Planning Application Ref: BR/93/20/PL

Location: Mordington Cottage, 6 Mead Lane, Bognor Regis, PO21 1HR

Description of works: Change of Use from office (B1(a)) to 1No. dwelling & the provision of new garden boundary wall to the South of property. This application affects the setting of a Listed Building & affects the character & appearance of the Upper Bognor road & Mead Lane Conservation Area

PROPOSED PLAN

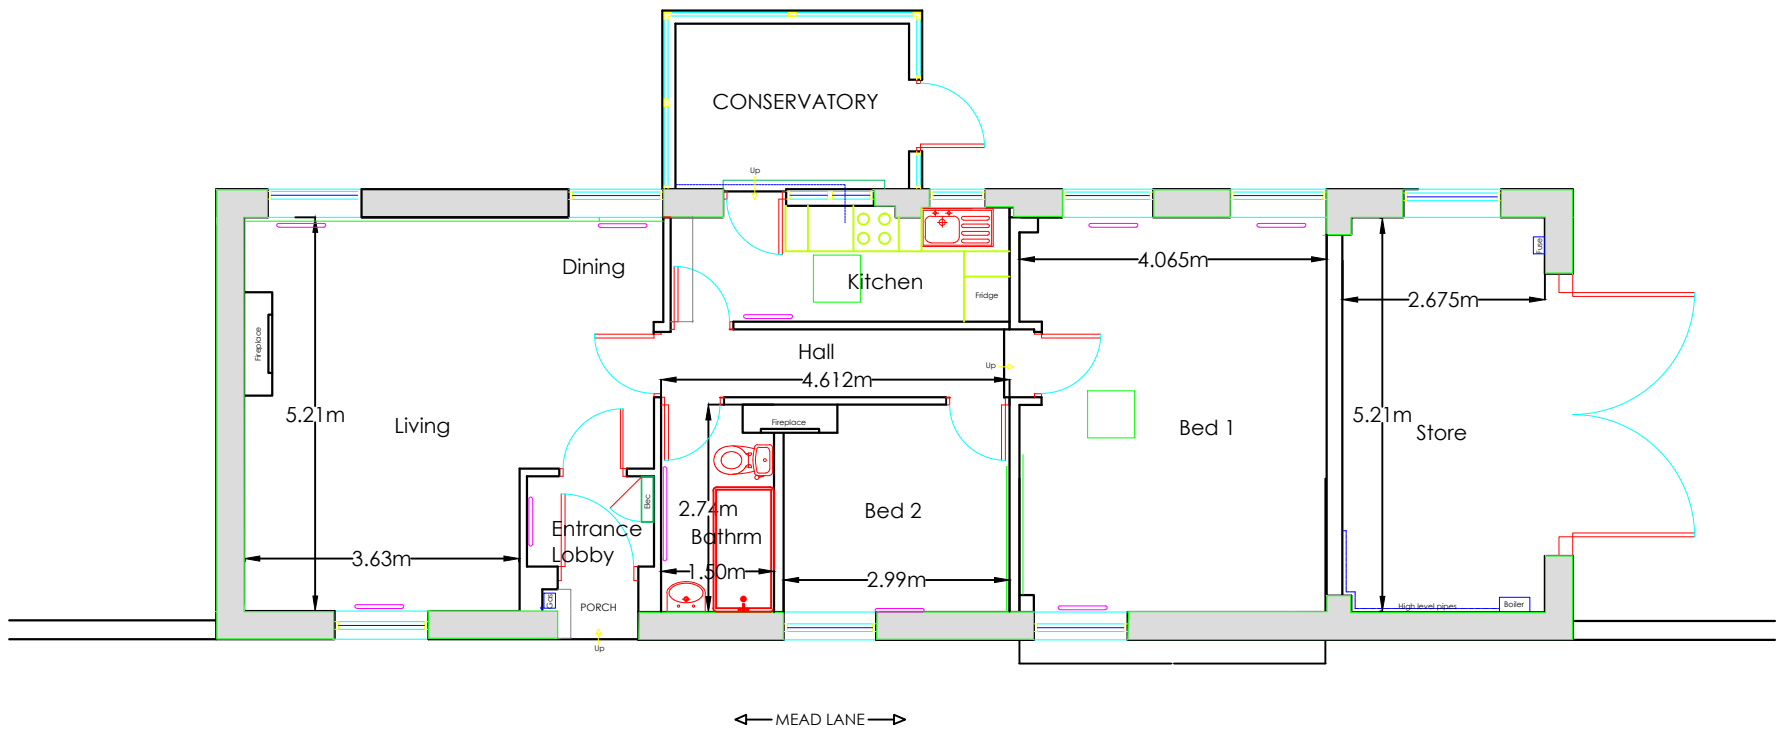
- There appears to be one tree that is likely to be affected by this proposal; a small but established tree on the edge of grass/shrub border (see p4) which may need to be removed or at least endure root severance to facilitate construction of the wall extension. Although protected within the Conservation Area, its loss would not have a significant detrimental effect on the character of the area. That said, we cannot endorse its removal if it grows from beyond the site perimeter. I assume the applicant will be aware of which person/organisation owns said tree and will seek their approval before undertaking any necessary pruning work/removal.
